Please ask for: Ms Iqraa Malik
Email: iqraa.malik@terraquest.co.uk
Telephone: 01212341390
Our Ref: M/82/20/HH
Your Ref:
Date: 5th November 2020

Application for Planning Permission for Works or Extension to a Dwelling

Development: Ground Floor Extension. Two Storey Extension. Small Side Extension. Addition of Carport. Exterior materials change to render and cladding.
Location: 18 Manor Way Elmer Middleton-On-Sea PO22 6LA

LOCATION PLAN

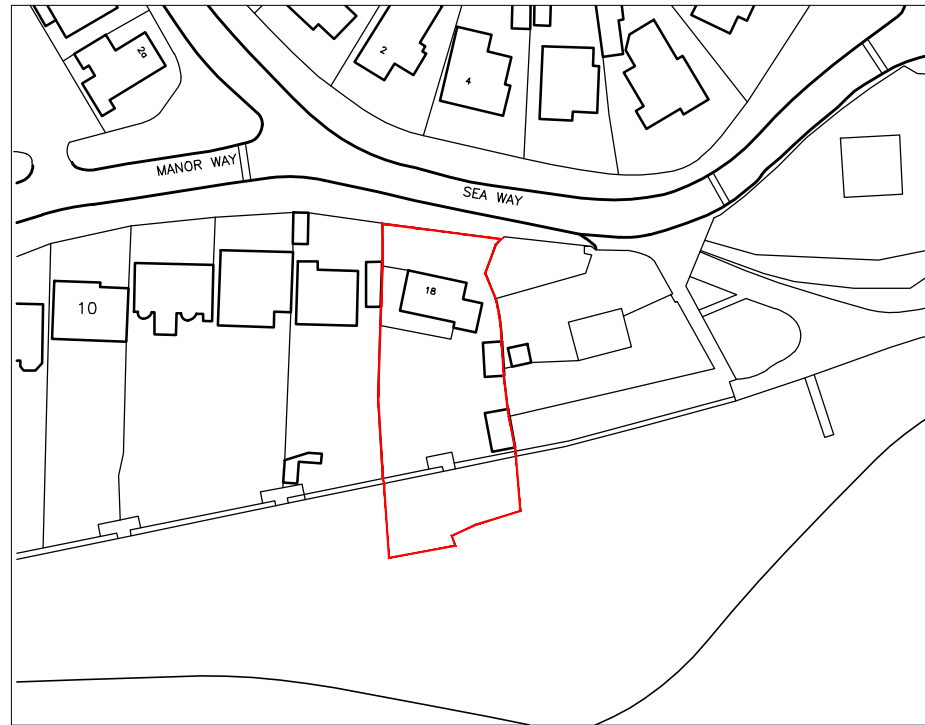
Location Plan

Please submit a copy of a location plan at a scale of 1:1250 or 1:2500 for rural areas. Further details of what must be included on the plan can be found in the Validation Requirements List.

LOCATION PLAN - 1:500

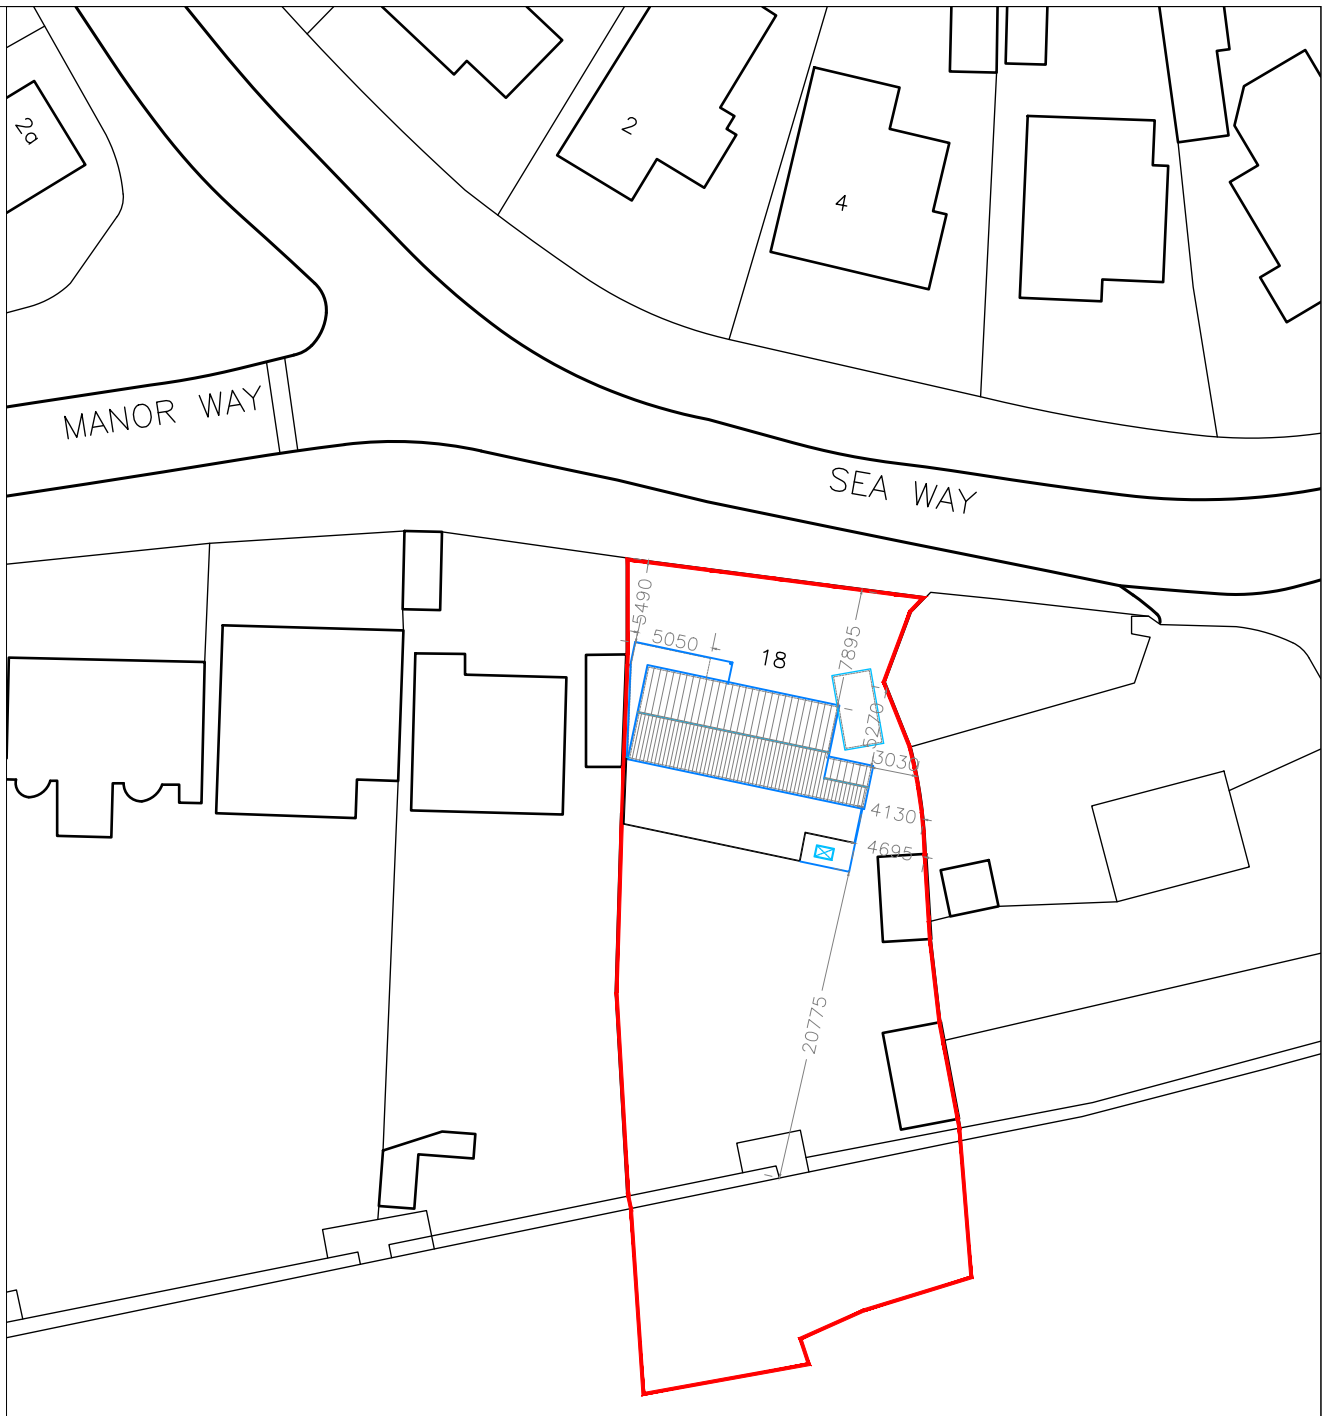
Block Plan

You are required to have dimensions from the proposed extension(s) to all site boundaries. Please amend.
